PLAN REVIEW SHEET

Date: July 27, 2023

Petition #: 2023-043

The site is located at 1723 Alleghany Street that is served by CATS bus route #30 along Ashley Road.

RZ-1

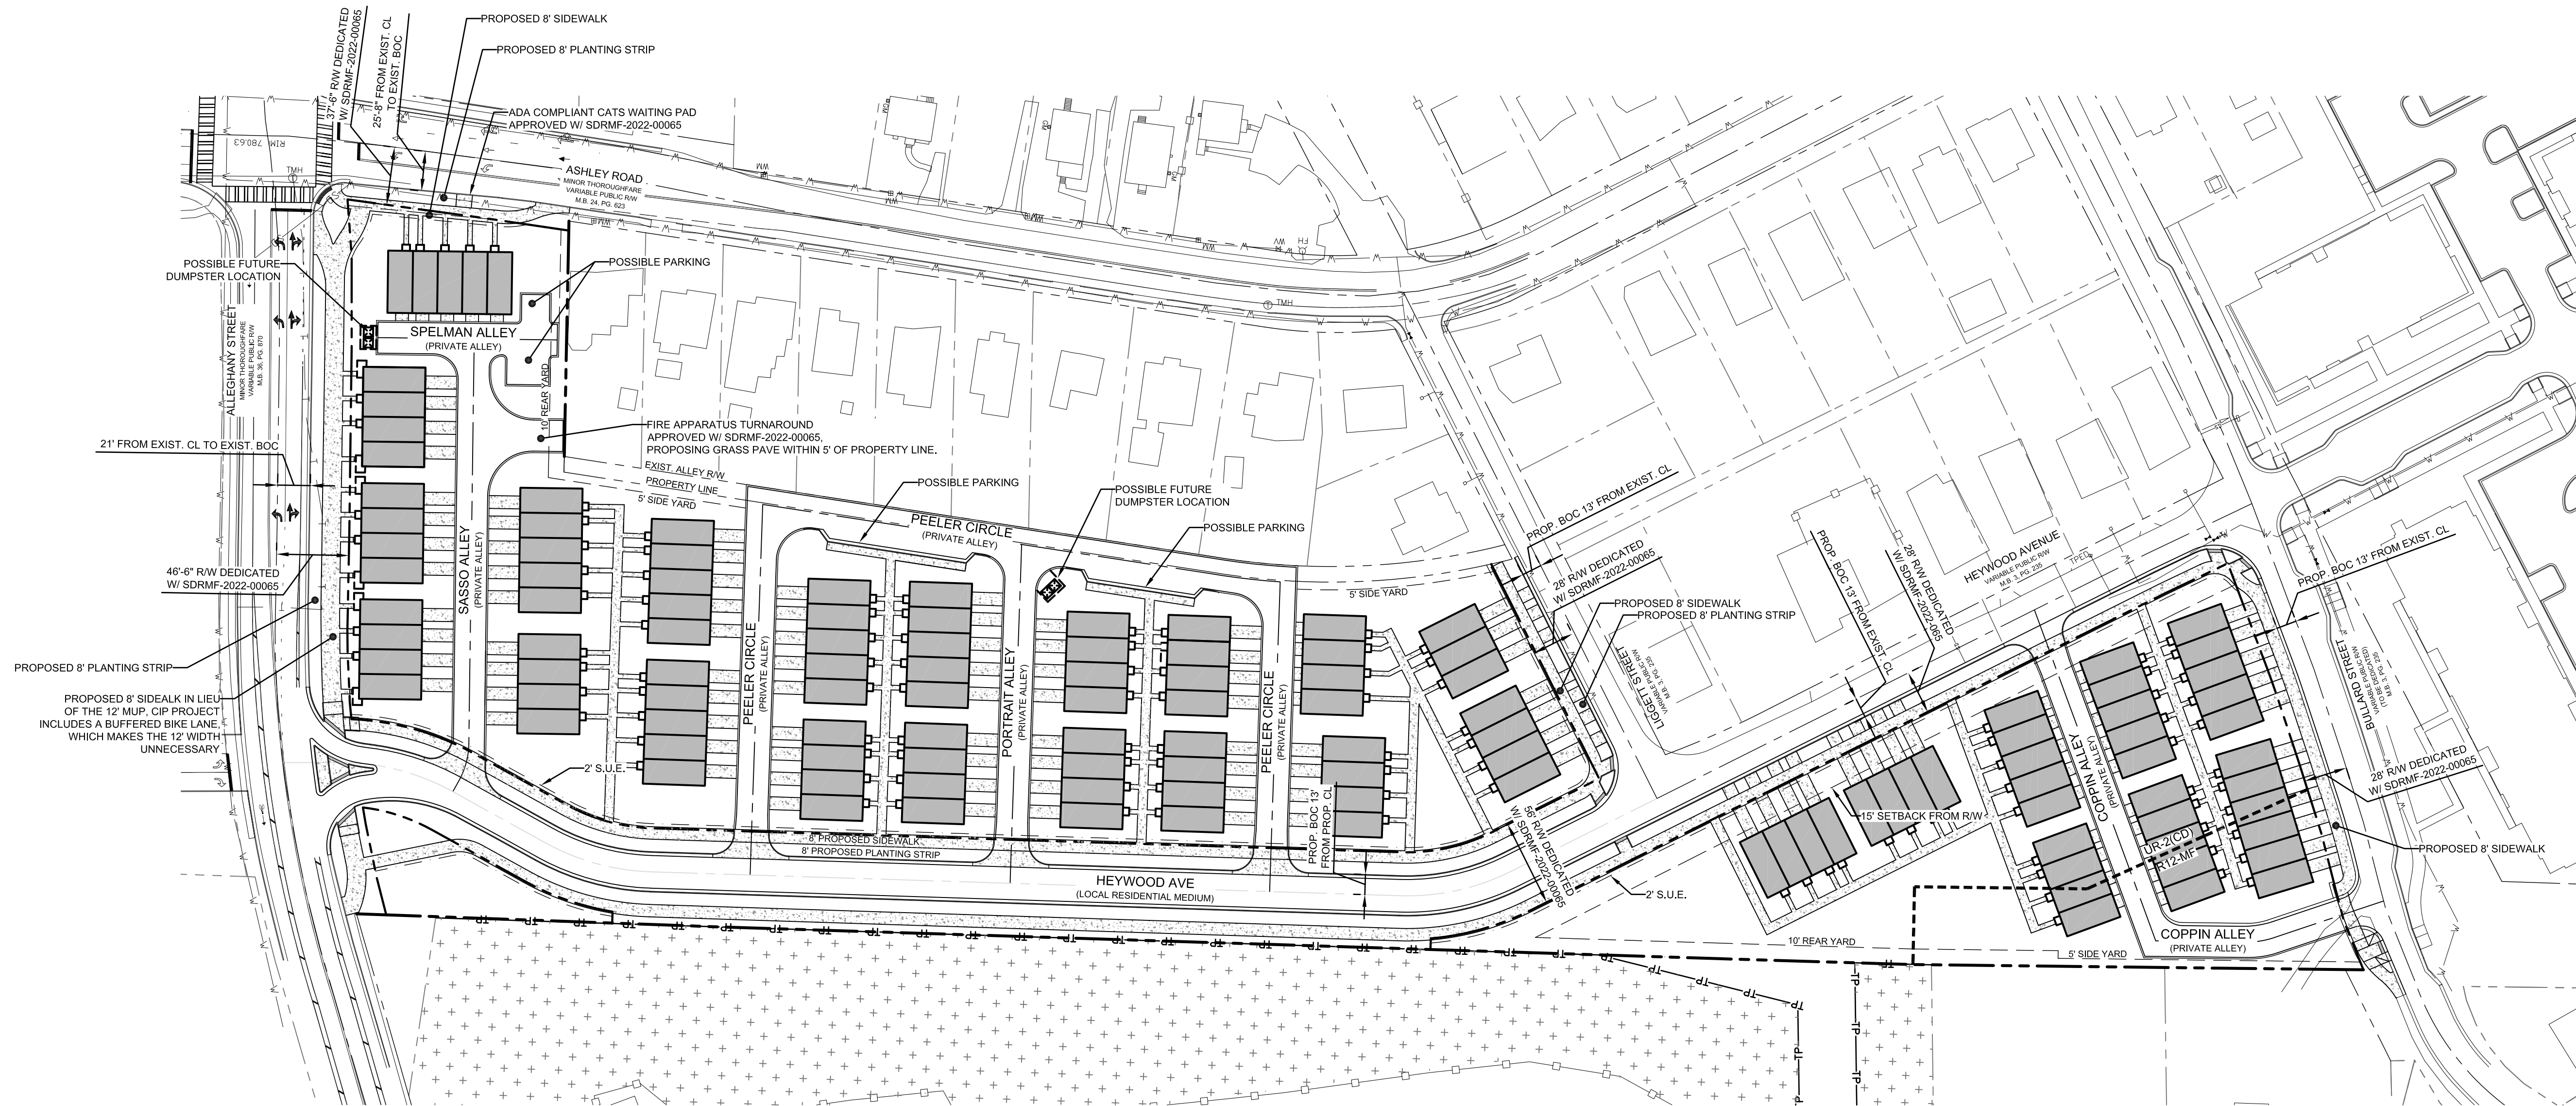
CATS requests the construction of ADA compliant bus shelter pad standard 60.03A on Ashley Road at least 50 feet from the crosswalk at Alleghany Street. CATS will consolidate the existing stop on Ashley Road in front of the single family parcels.
